Name: Barry Arthur  
Organisation: Wingecarribee Shire Council (Manager Environment and Sustainability)  
Govt. Agency: Yes  
Email: barry.arthur@wsc.nsw.gov.au

Submission for Job: #6334 Sutton Forest Quarry Project  
[https://majorprojects.acelo.com/?action=view\\_job&id=6334](https://majorprojects.acelo.com/?action=view_job&id=6334)

# Submission to the Sutton Forest Quarry Project Environmental Impact Statement

QUARRY ACCESS ROAD LAYOUT

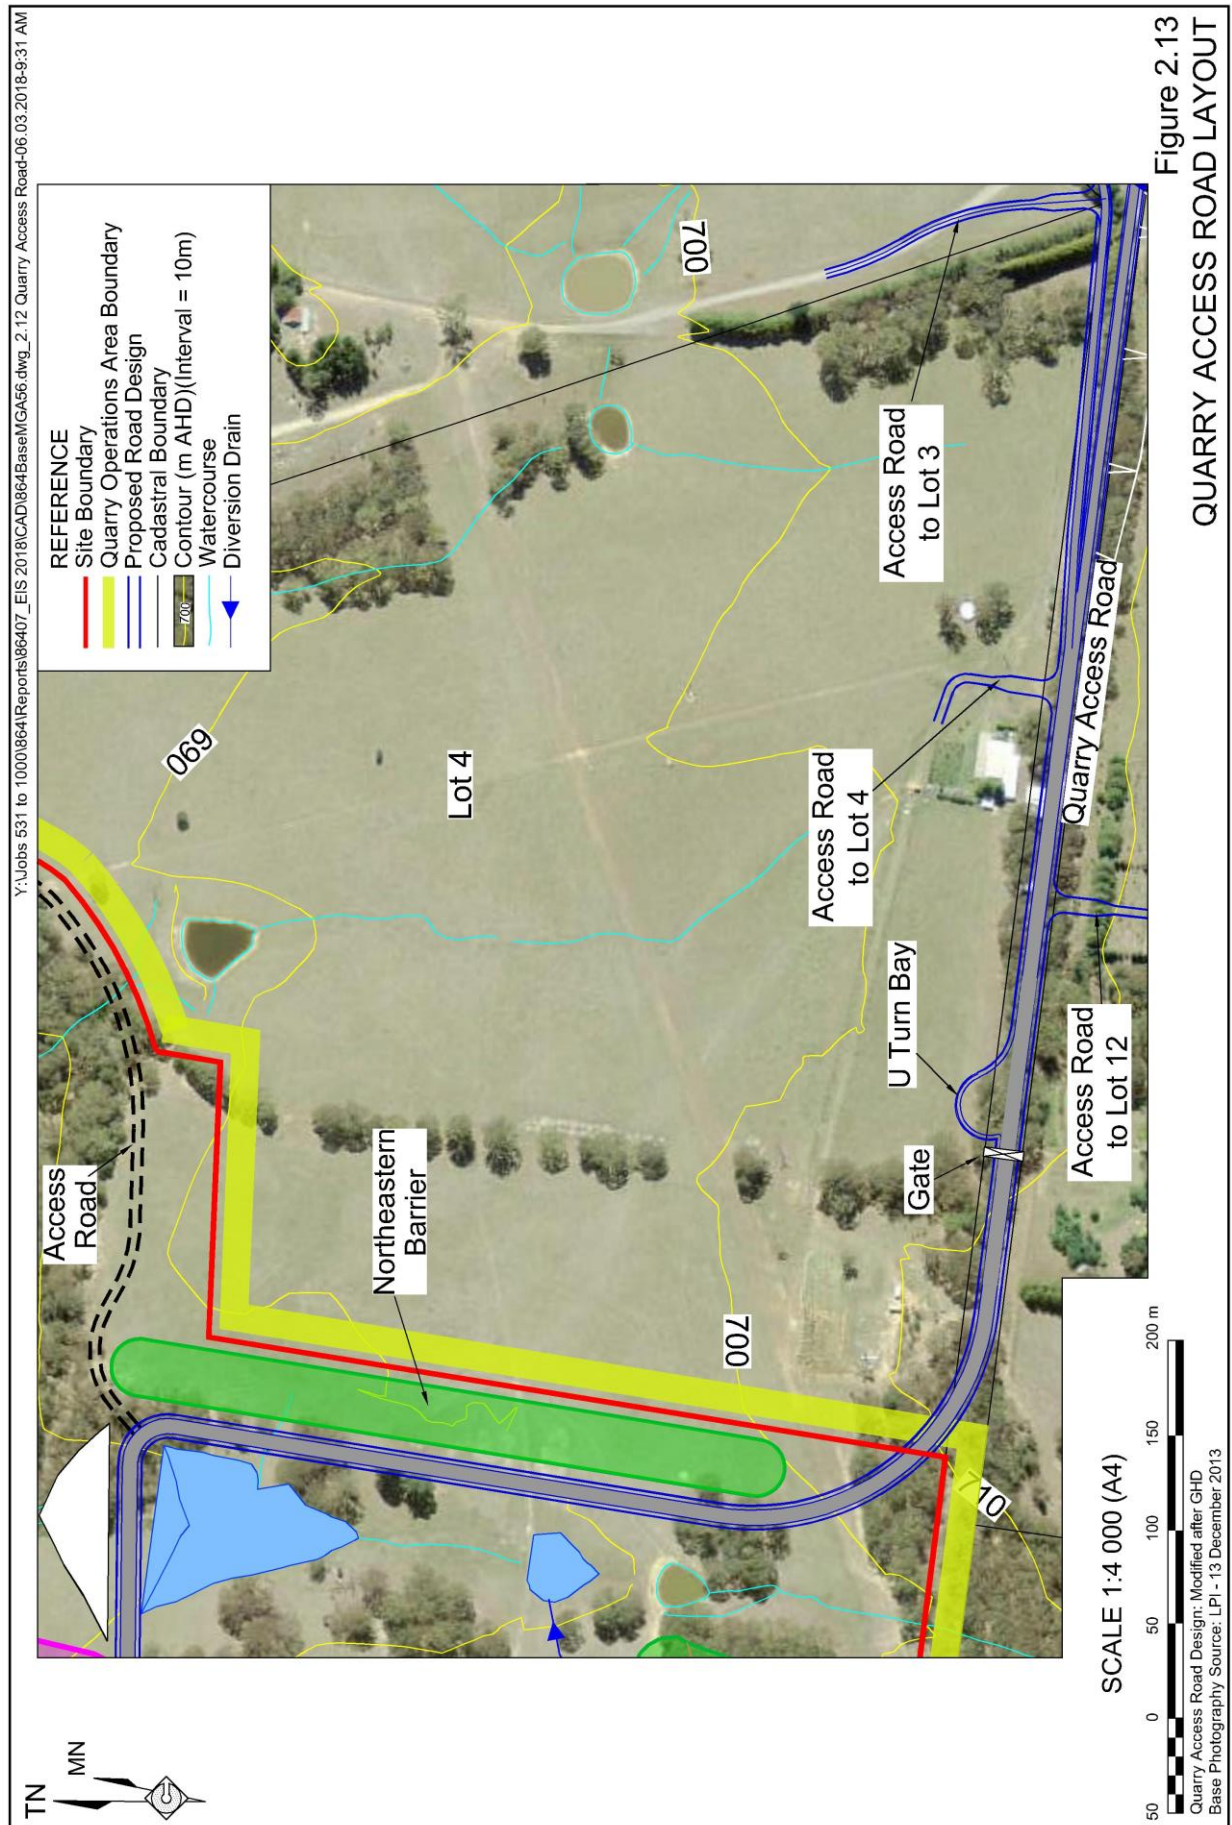
45. It is unclear of the full impact on the Kingsbury VC rest area. Most of the rest area appears to be built over by the overpass ramp. No plans are outlined how this area will be rehabilitated / relocated / removed.

46. There is no detail on the impact to forestry vehicles entering and leaving Penrose Forest. The proposal needs to accommodate safe entry and exit of forestry vehicles, and ensure all access requirements are incorporated into any plan.

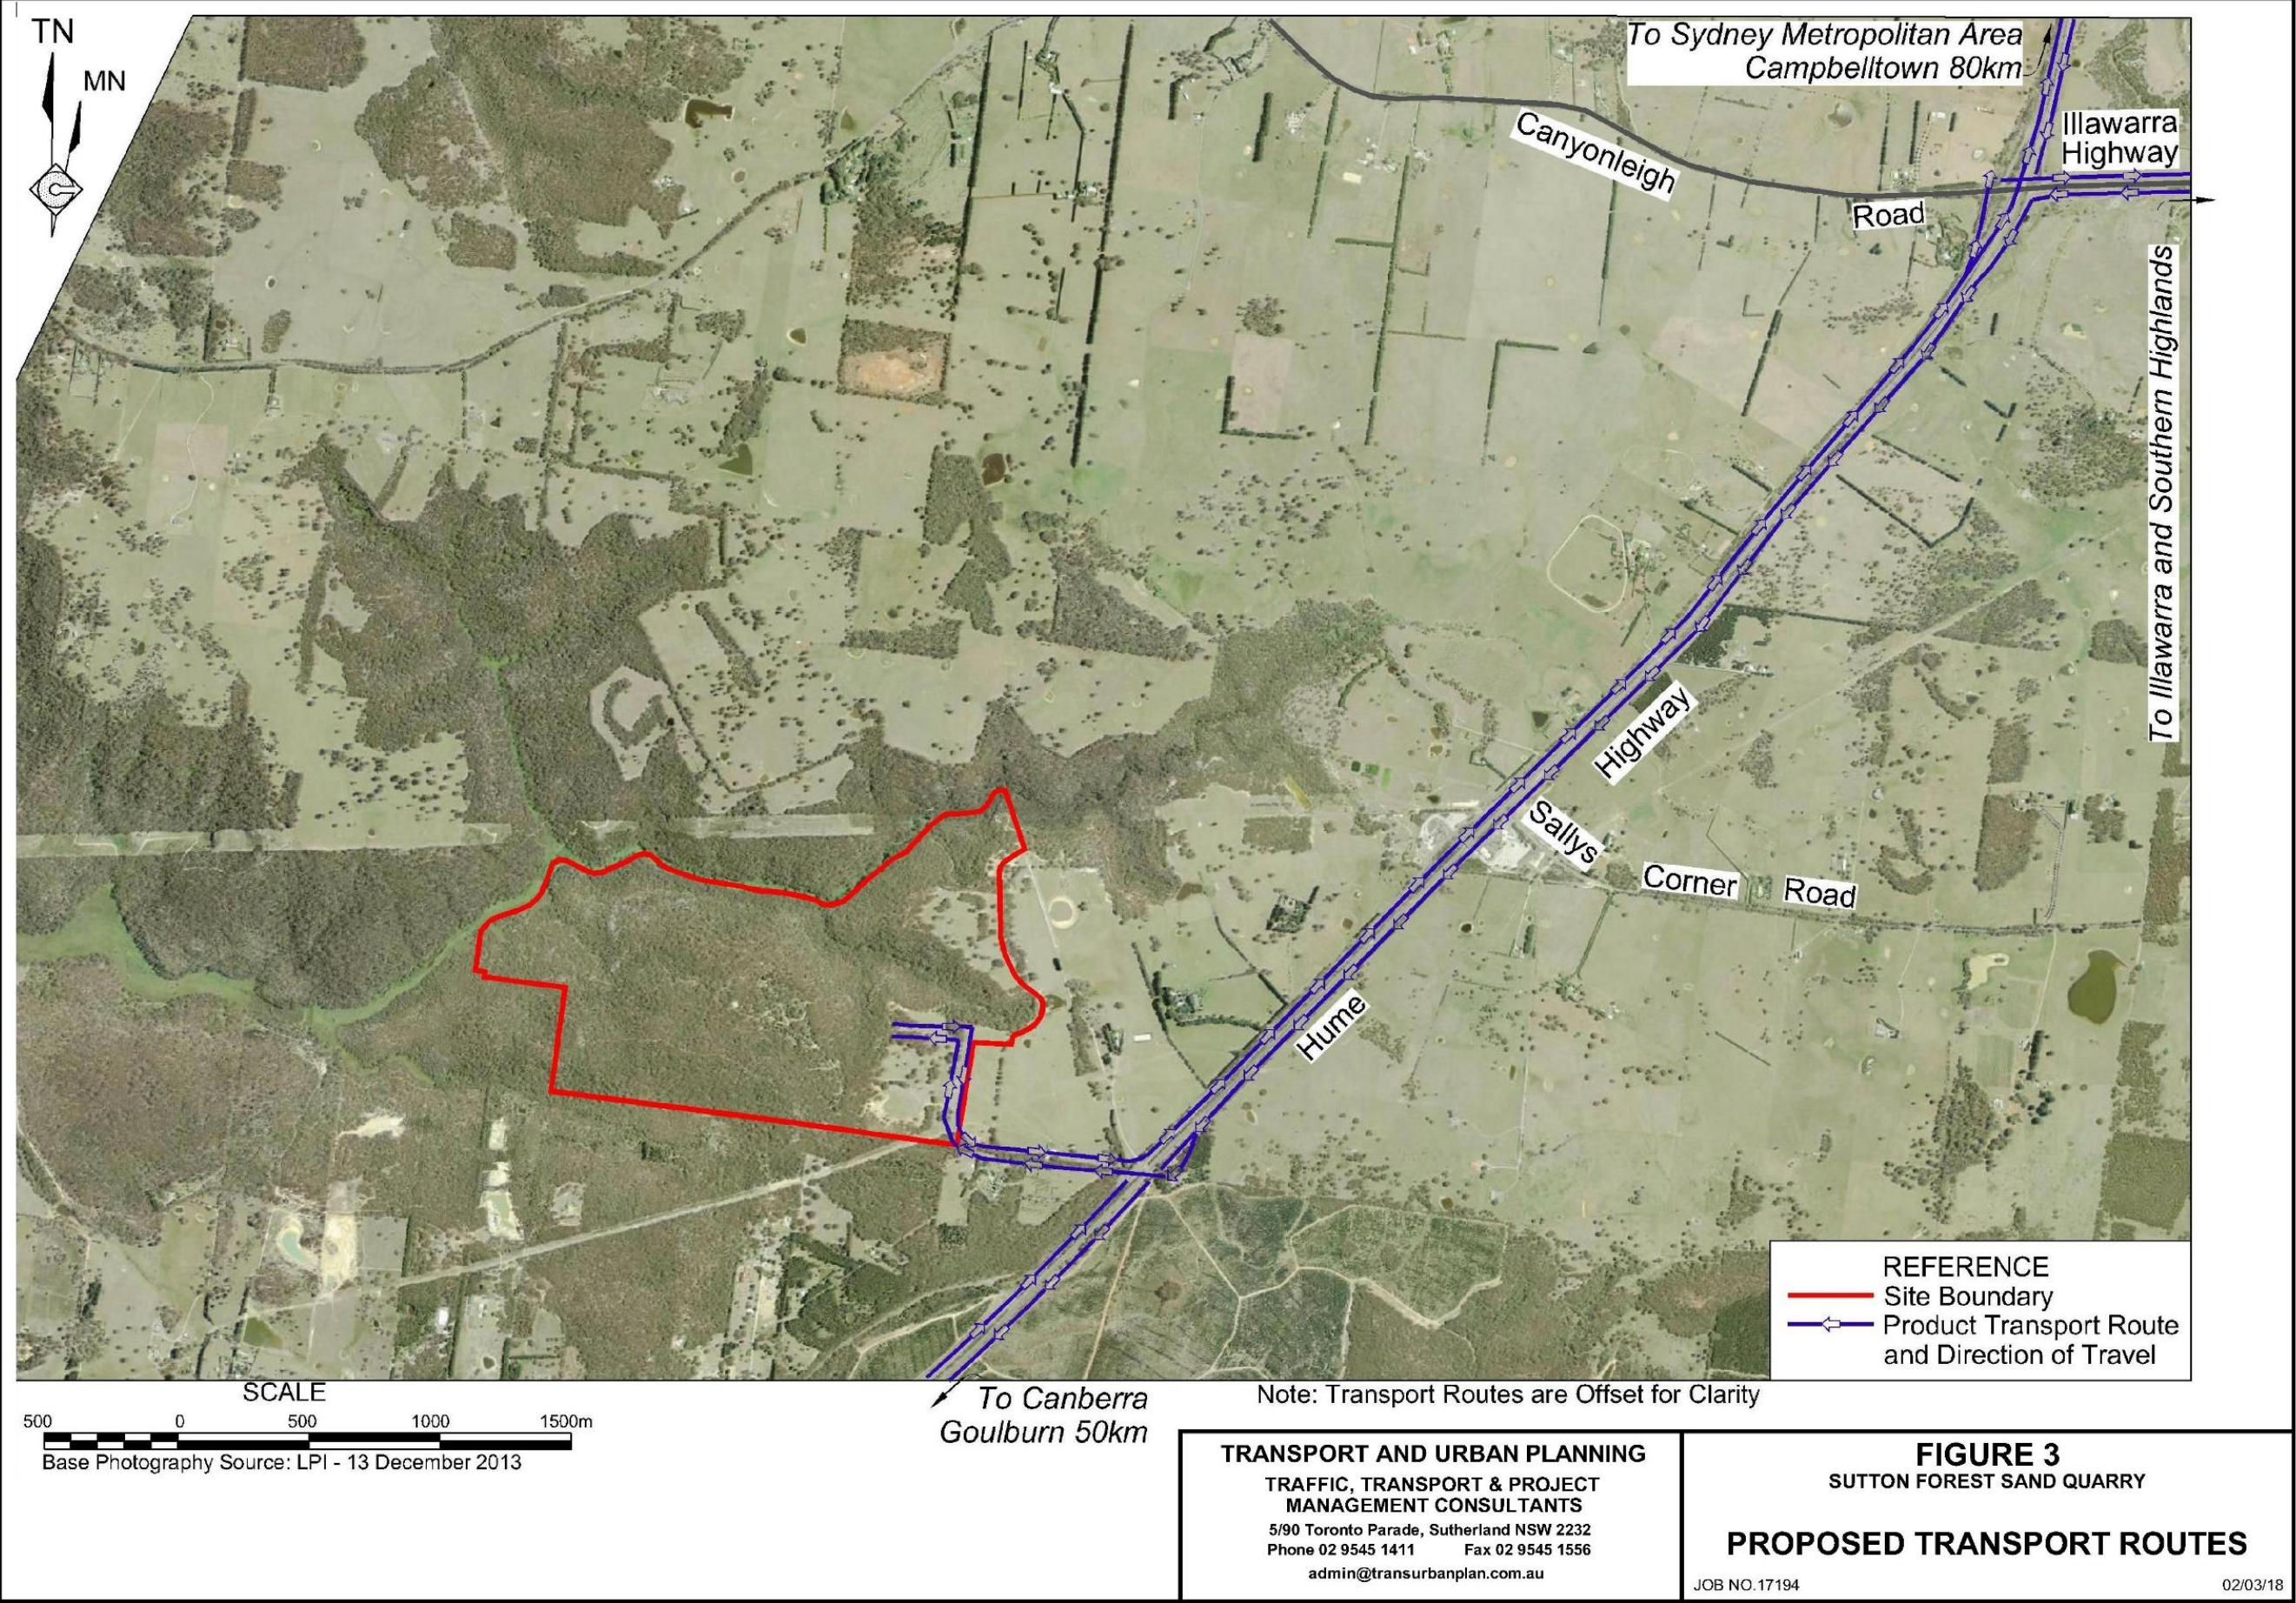
41. The Hume Highway interchange is not in ideal location as it incorporates, and introduces too many new elements to the road network and associated infrastructure at that point (including connectivity to the Kingsbury VC rest area, Penrose Forest Way, the northbound rest area, and Sally's Corner Interchange).

42. There is lack of detail on the impact at the highway interchange. Design of the interchange needs to be supported by detailed traffic analysis showing all existing and proposed movements at this point (including peak truck movements associated with forestry operations).

47. The EIS should provide detail how it will limit operational and construction truck movements through Sally's Corner Interchange.
48. Given the size and duration of the project, it might be more appropriate to consider a suitably integrated full interchange at the Highway that incorporates both north and south access and accommodates existing users (including private landholders and forestry traffic).
